Date: 10th July 2024

Kirklees Council – Planning Applications: 2024/91316 and 2024/91317

1 PROPOSED SITE LAYOUT  
1 : 500

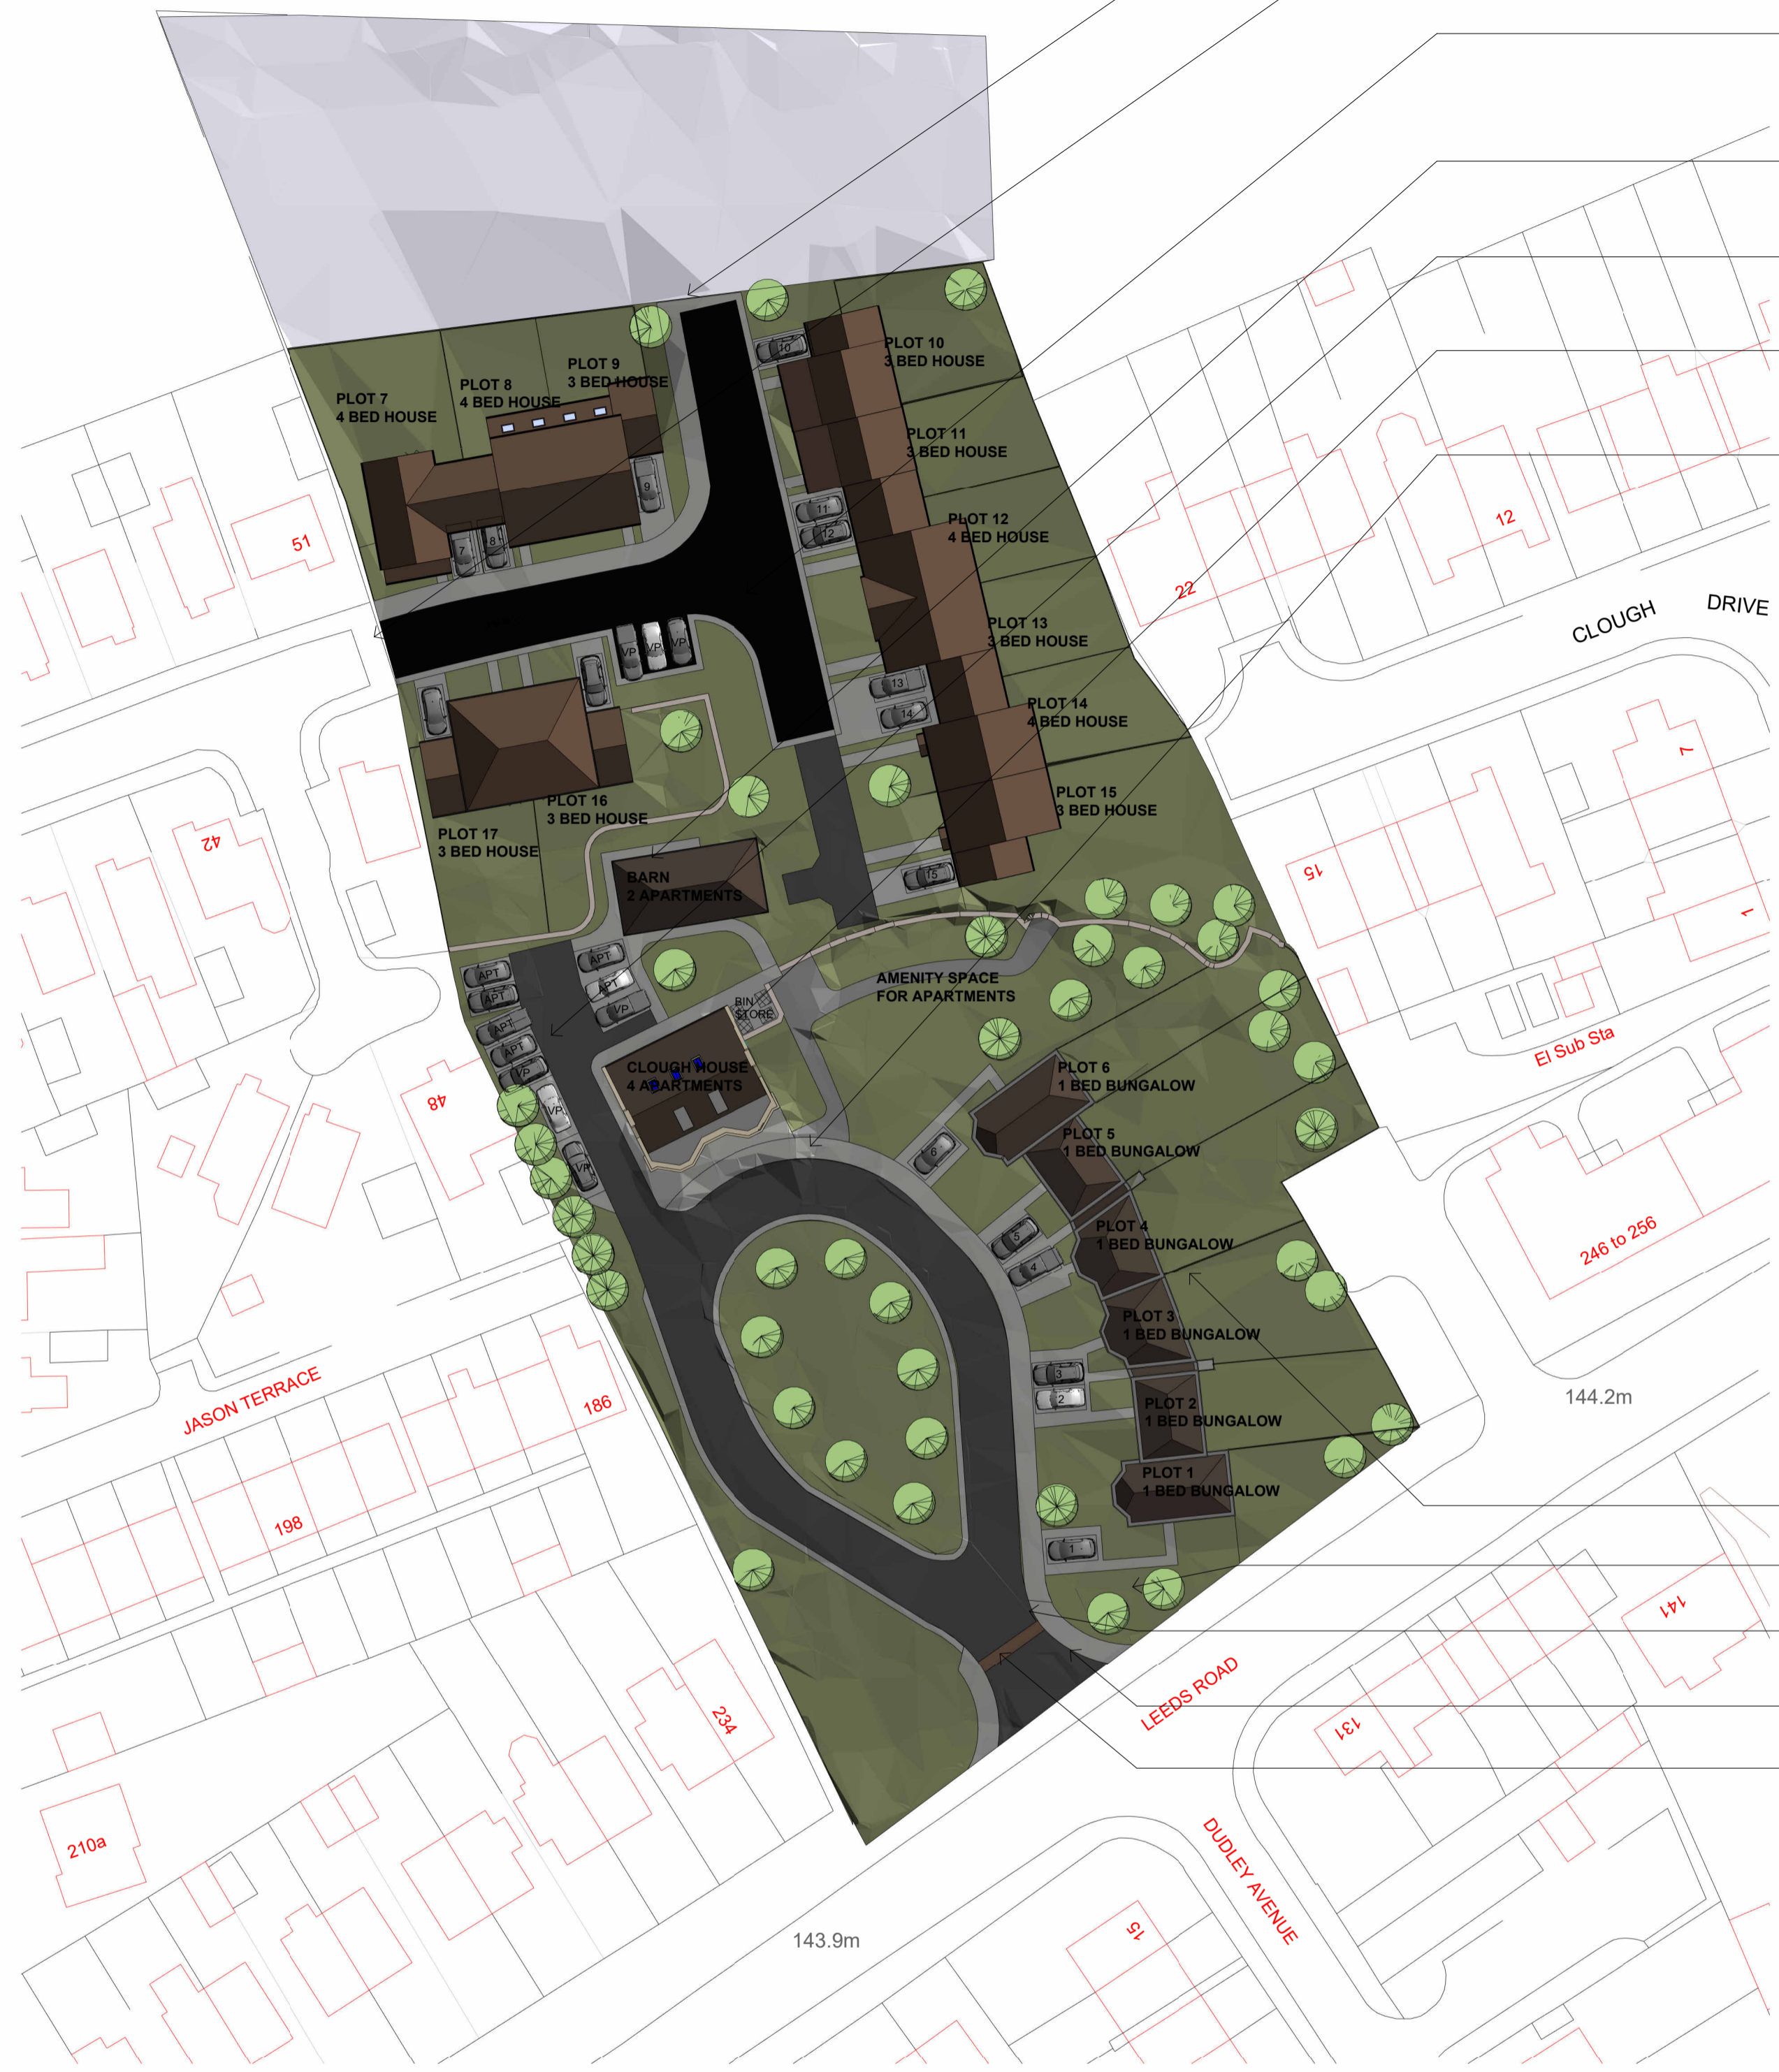
What I do object to is the access via Moat Hill Farm Drive. There is currently no access to the site from here (it states in the plans there is) as it is a cul-de-sac location with a pedestrian pavement all around the cul-de-sac enclosed with a solid wooden fence, behind this is the boundary wall and has been like this since they were built back in the 1990's. The proposed access/entrance also goes over where my boundary line is on the land registry (of which I have already sent to the council). The residents, most of who have lived on the street since the houses were built, bought them as they are in a quiet cul-de-sac location.

Highways transport statement states that Moat Hill Farm Drive has low traffic volumes during the day. Whilst this is their opinion, I would welcome sight of evidence on how they have come to this when they have visited at peak times, weekends and holiday times. As a resident I can assure you that at peak times there are cars and vans parked both sides of the road, parked cars on the bend at the top making it a blind bend. This has got worse since the new builds up Moat Hill Farm Drive were built a couple of years ago. Trying to get through, is on numerous times a struggle let alone an accident waiting to happen. Moat Hill Farm Drive already serves access to Jason Terrace and Rose Terrace, there are currently 17 properties on Moat Hill Farm Drive, in addition to the 10 newly completed houses on the left hand side going up the hill, 13 properties on Jason Terrace, 6 properties on Rose Terrace and 3 houses which have a Leeds Road address all of which require pedestrian and vehicular access to Moat Hill Farm Drive. All these addresses currently use Moat Hill Farm Drive for parking and access to their homes and often are parked both sides of the road opposite each other making it very difficult for the smallest of vehicles to get through.

Moat Hill Farm drive is already very congested and in the more frequent freezing weather conditions a very dangerous road to be on and putting access to more vehicles and pedestrians when you already have a much safer and shorter route via the larger already existing Leeds Road entrance / exit. There is no reason why this access cannot be amended on the plans to make it a one way in / one way out access like there currently is on neighbouring streets like Clough Drive, White Horse Gardens (completed in June 2016 consisting of 12 3&4 bedroomed homes) and White Horse Close

I sincerely object to idea of the access to the new development and opening up of Moat Hill Farm Drive as it would only add to the already congested traffic we currently deal with on a daily basis. I do support the development for the build of new houses however I would like to know which of the home are in the affordable housing scheme?

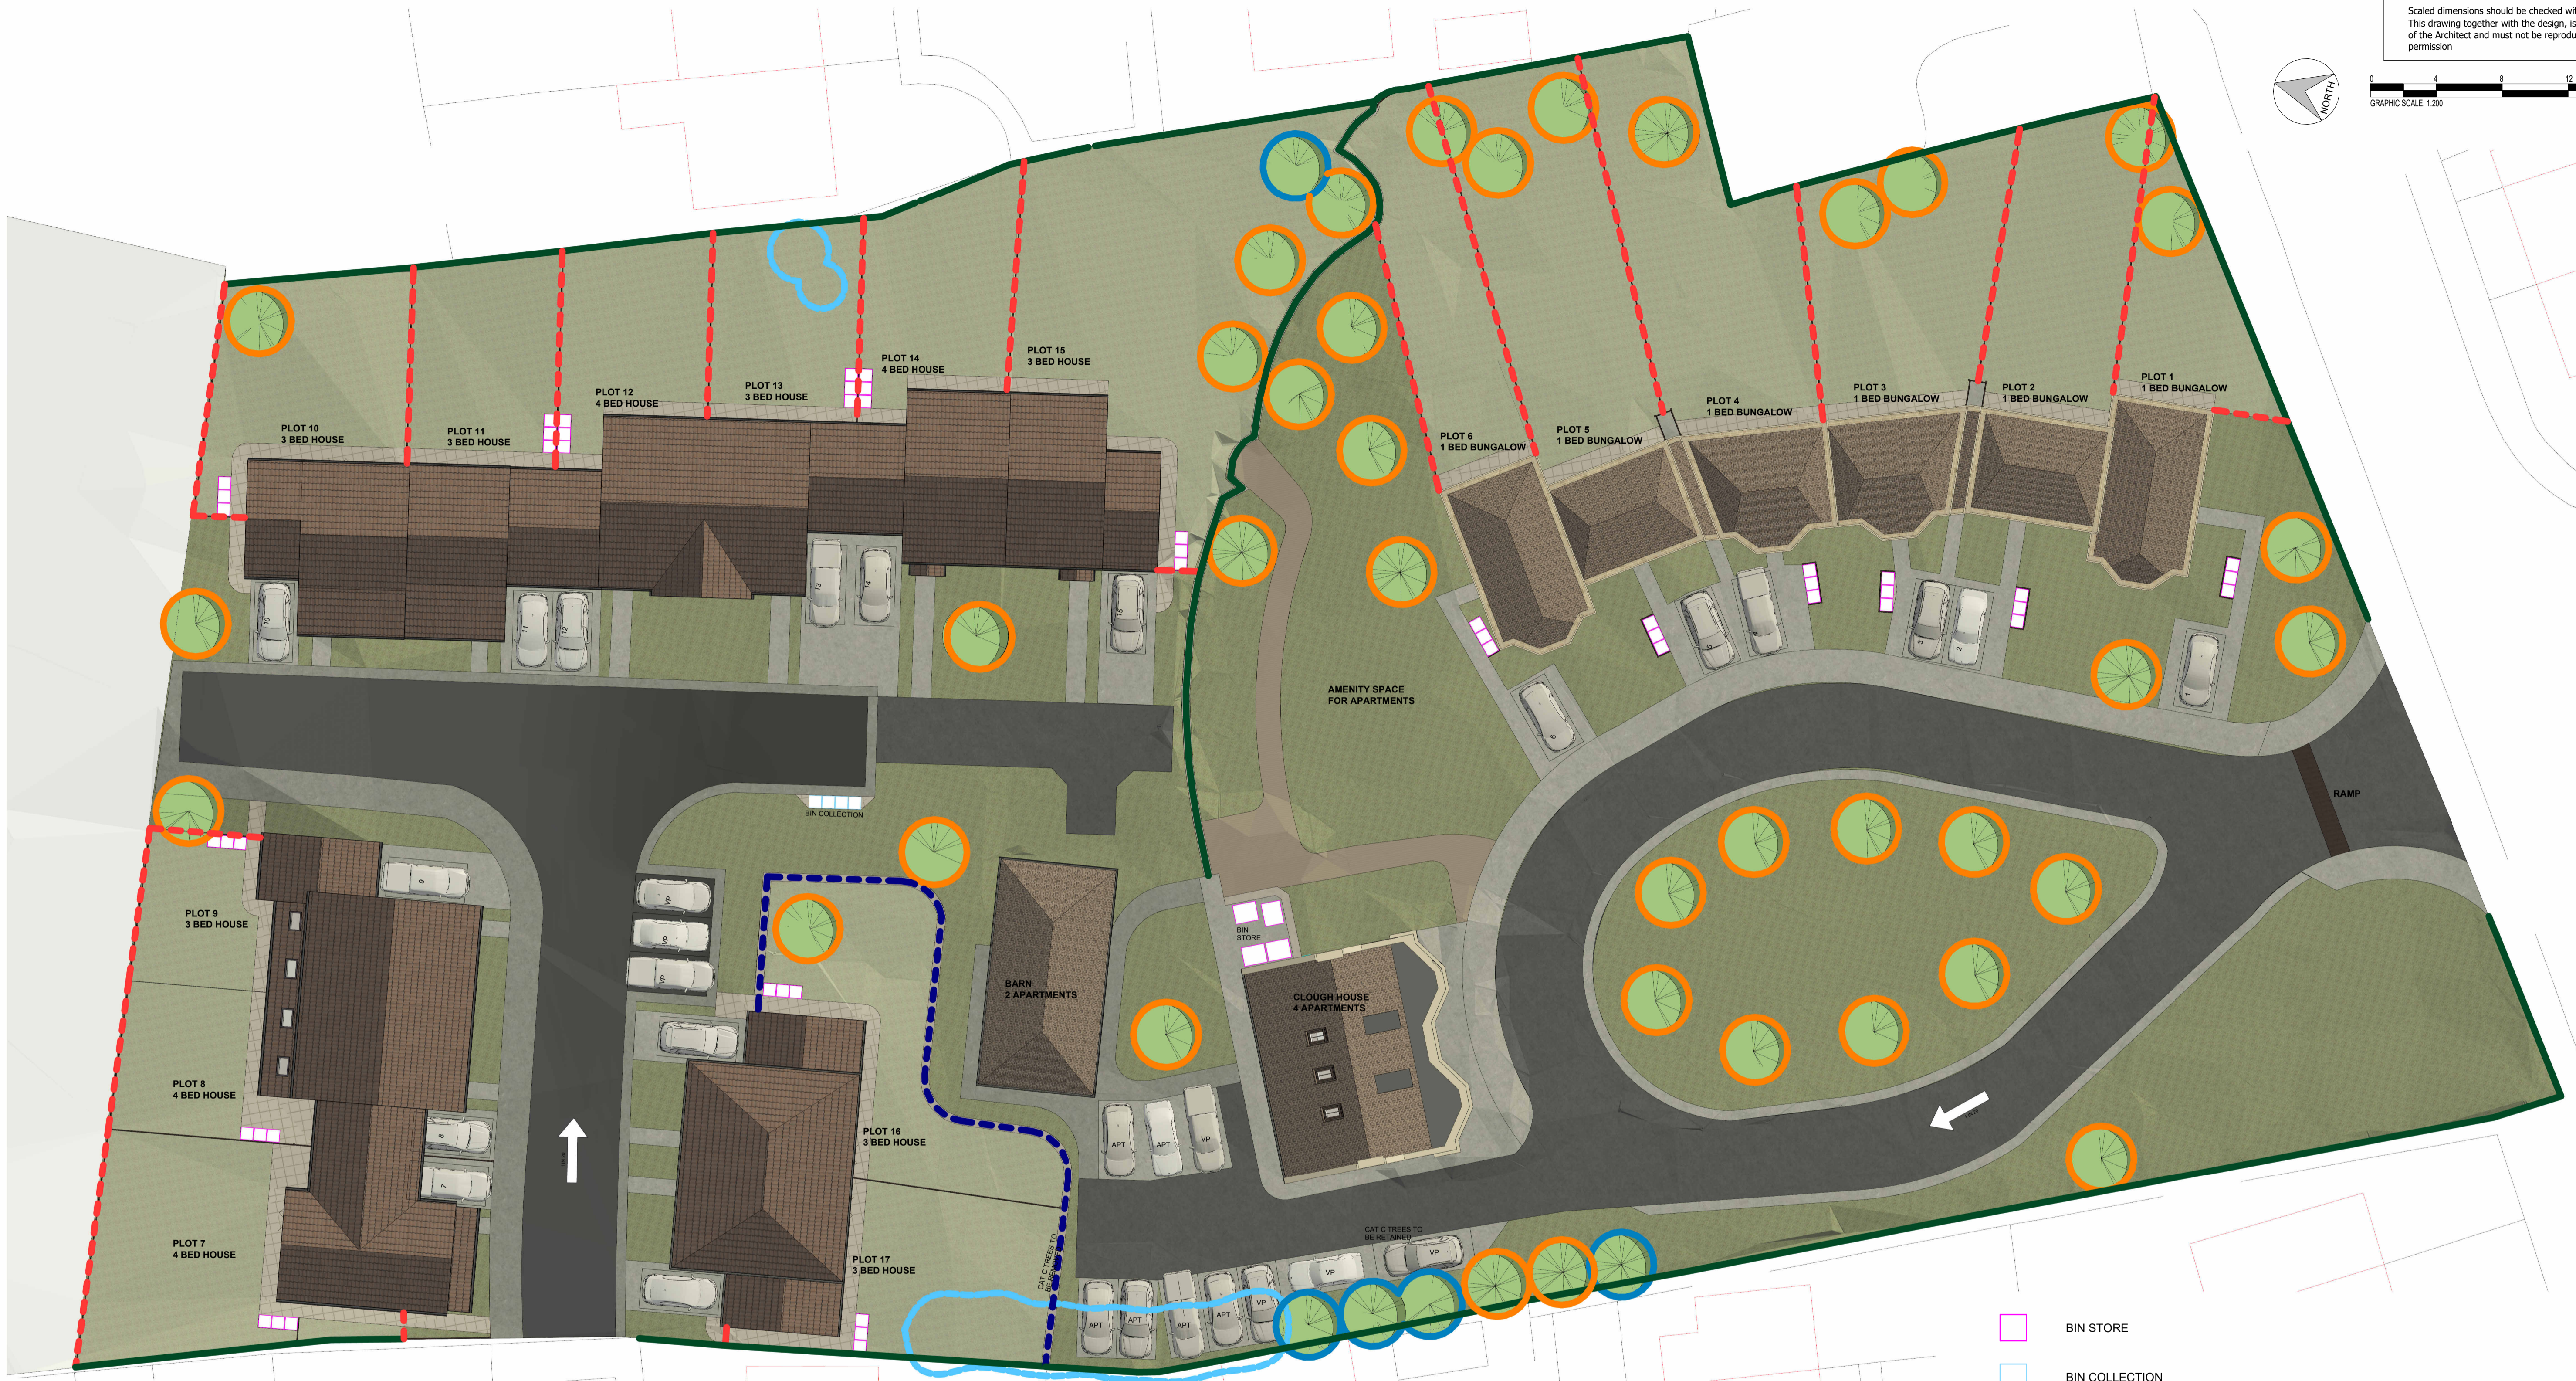
Also, I want to keep the privacy of my garden from the site with the existing trees that are well established and are home to wildlife and bats that are regularly seen, if this is not going to be left then what screening will be put in their place at a height to keep the privacy?.
